**Consultation Response from KC, Highways Development Management (HDM)**

**2022/92471 Heckmondwike Hub Bus Station, Royle Fold, Heckmondwike, WF16 0HW**

**Redevelopment of Heckmondwike Bus Station including a new concourse building with waiting room, Changing Places WC, driver offices, 6 No. bus stands, landscaping, and associated works**

**RECOMMENDATION: Further information required**

1 Planning Site Plan
1 : 200

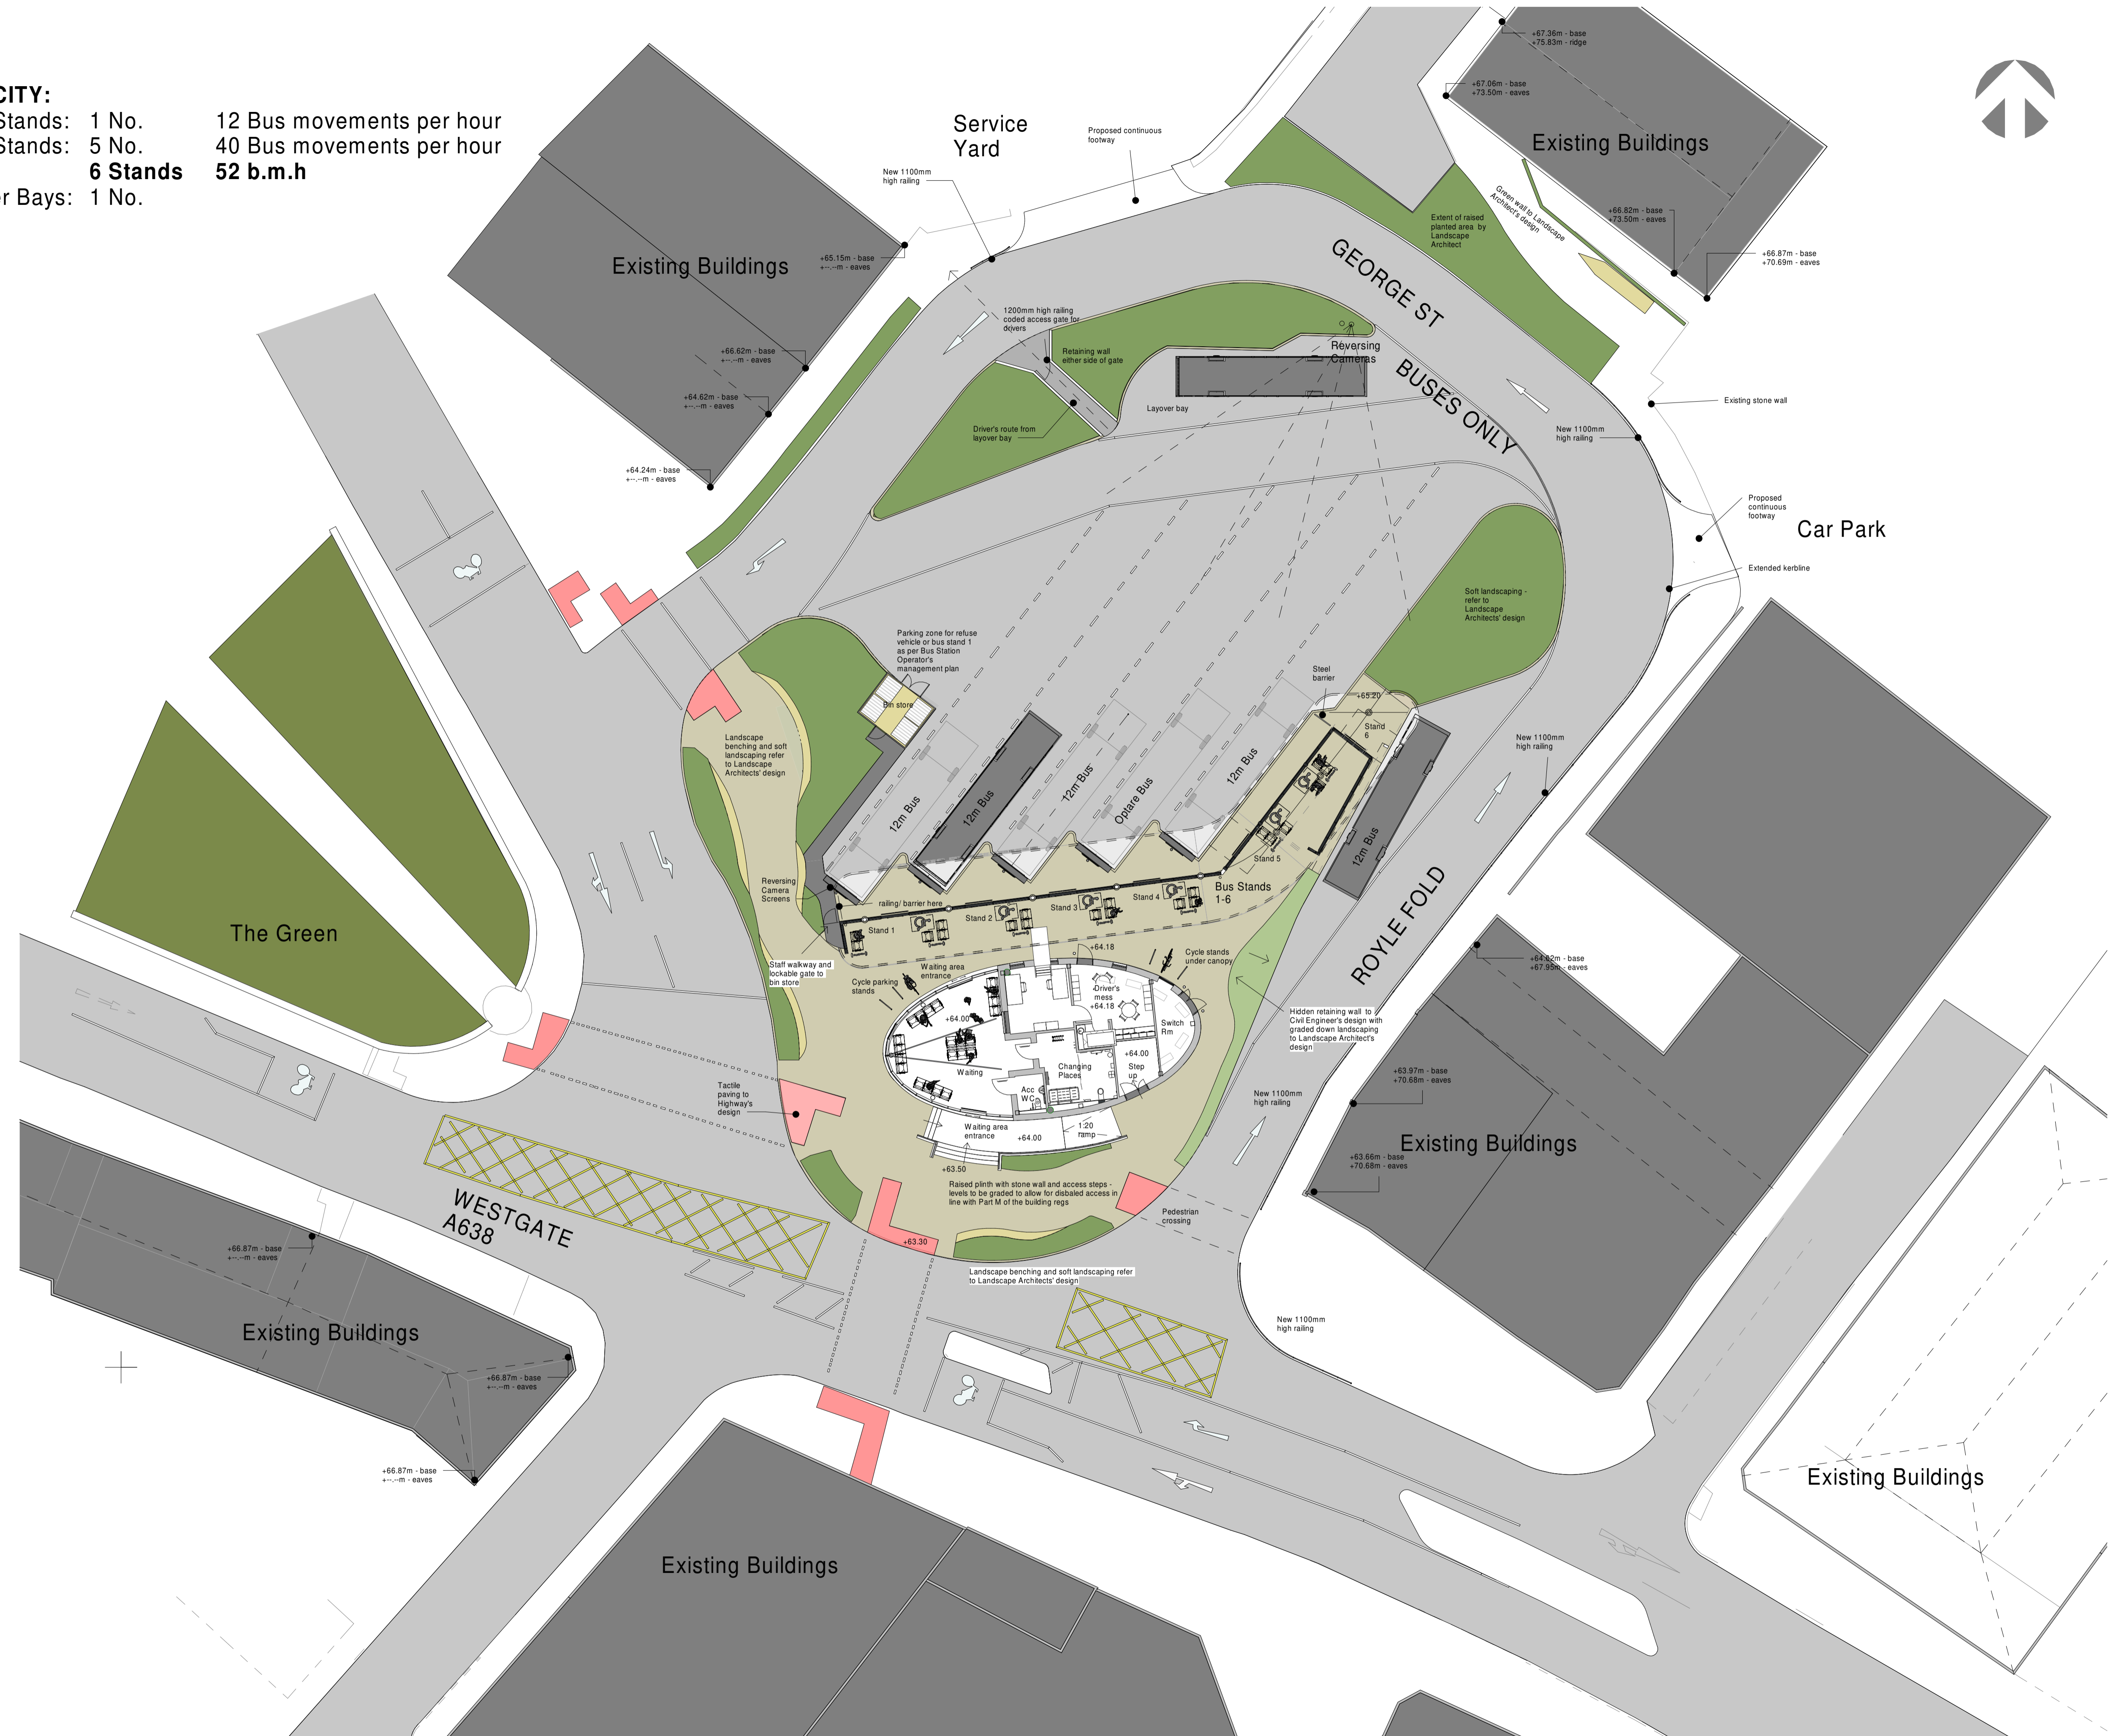
The Transport Assessment includes swept path analysis (SPA) for proposed bus stands 1-5 that generally appears to be acceptable. However, no SPA has been provided for bus stand 6, the layover bay, the bin store bay or the dentist access. Therefore, it is unclear whether these facilities will be able to operate safely and effectively, with specific concerns as follows:

- For bus stand 6, it appears that a bus needs to align exactly with the boarding area to ensure that a waiting bus does not block access to other vehicles passing on Royle Fold, and to ensure that safe access for boarding/aligning passengers. However, without SPA it is unclear whether buses will be able to align their bus in the require position without blocking the circulation route.
- For the bus layover bay it is unclear whether buses are expected to enter and exit in forward gear, which is likely to be necessary given that safe reversing will not be possible. Should buses be required to enter/exit in forward gear, which appears necessary (e.g. as there is no reversing camera for the layover bay, and as reversing back onto the highway is not

acceptable), this would mean that bus drivers are only likely to be able to access bus stands No. 5 (and possibly No. 4) in forward gear. Therefore, in addition to providing further SPA, further details of how the layover area will be used and managed is required.

- It is unclear how bin collections will be managed and the type of vehicles that will be used for collection, as at present the bin store vehicle waiting area looks very small, and does not appear to be accessible without driving over the bus stands No. 1-5. Therefore, in addition to providing further SPA, further consideration of how bin collections will take place and be managed is required. It is noted that detailed comments have been provided by the Councils Waste Strategy Team, which have been provided at the end of this response.
- It is unclear whether the dentist access will still be able to accommodate refuse vehicle access following the narrowing of Royle Fold. Therefore, SPA is required to confirm that a refuse vehicle can still service this site.

- It is considered that the gated access to the layover bay is unlikely to be used by bus drivers, who are more likely to walk across the bus apron to access their welfare facilities, given that the route is much more direct. Therefore, it is recommended that a safe route is provided with the bus station site instead. It is noted that the forward visibility requirements on George Street are also likely to require significant changes to the current access route and gate, which could be addressed by removing this route.

- The plan shows a new bin store/ compound on site. It is assumed that the operators will have experience of the amount of waste currently generated and the store has been scaled to accommodate an appropriate number of wheelibins. Guidance indicates the floor space for a 1100ltr wheelibins is 1575mmx1190mm with space to manoeuvre the bins within the store so the bin store dimensions would depend on configuration within the store. Dimensions of the store are approximately 3mx3,9m with a opening of 1.4m that should be sufficient for at 1100ltrs wheeliebin to pass through. The waste store should be constructed with an impermeable floor surface. Guidance on the floor footprint for wheeliebins and specification on construction requirements including screening can be found in the [Waste Management Design Guide for New Developments \(kirklees.gov.uk\)](https://www.kirklees.gov.uk/waste-management-design-guide-for-new-developments)

- It appears that RCV's will use the bus lane into the site to access the waste storage area. There looks to be just sufficient space to enable an RCV (11.22m) to park with the cab facing the waste store with waste transferred to the back of the vehicle for loading. If using George Street the RCV may reverse to the bin store. Reversing of RCV's is recognised as a health and safety risk both to collection staff and members of the public.

TITLE: **DRAINAGE PROPOSALS**

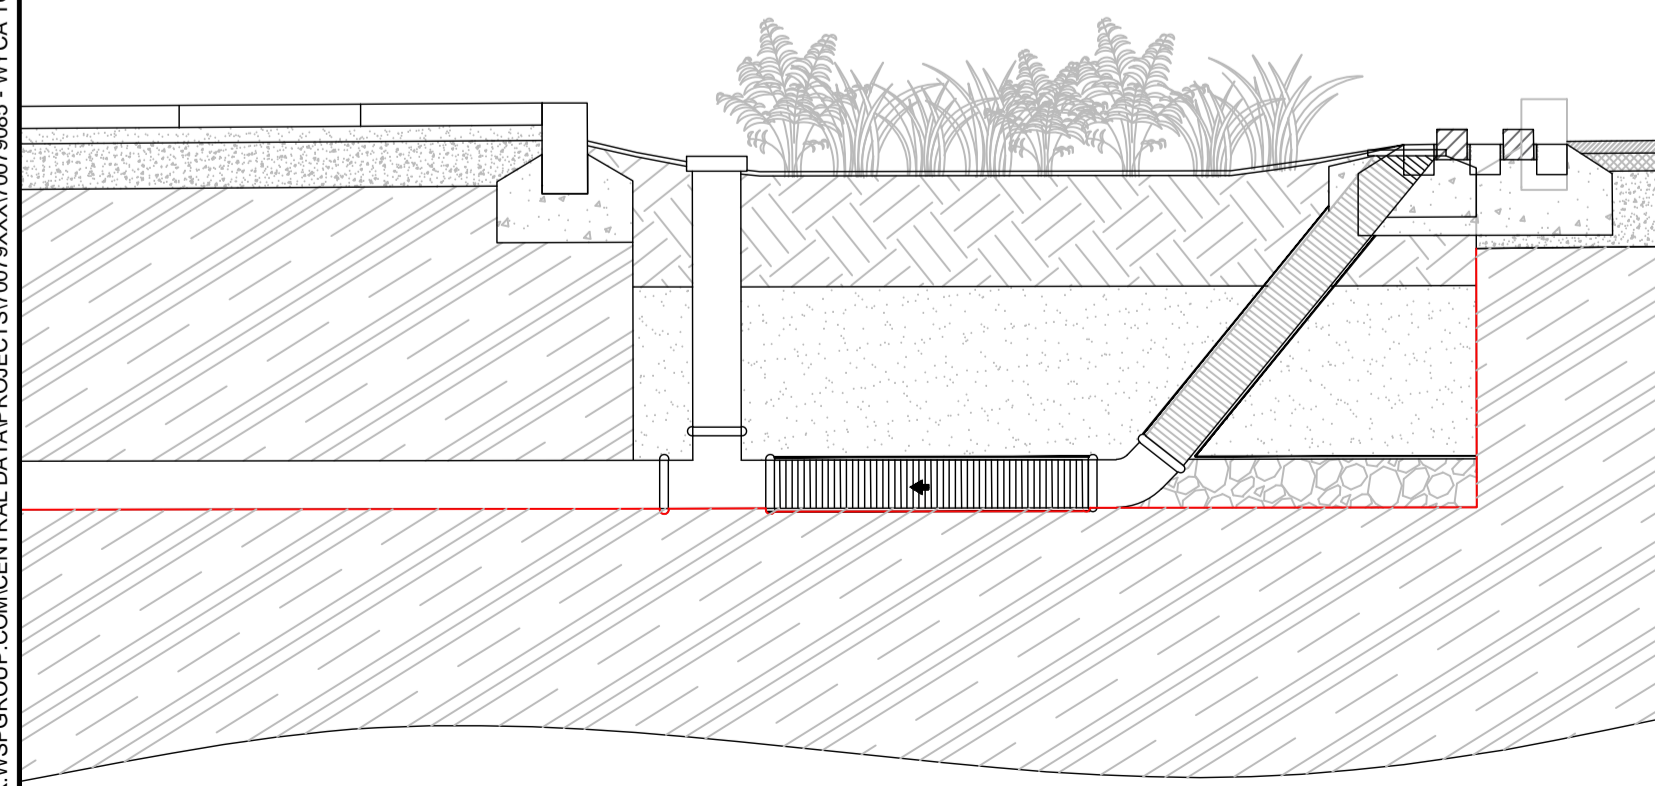
- SUDS proposals are shown within the footways in the adopted highway, but no details are provided of what is intended. However, it is assumed that these are proposed to be verges or permeable paving? Depending on the type of features that are proposed, it may be necessary to remove them from the proposals, as they could create maintenance or trip hazard problems if narrow verge strips are proposed or if water were to enter the highway sub-surface.
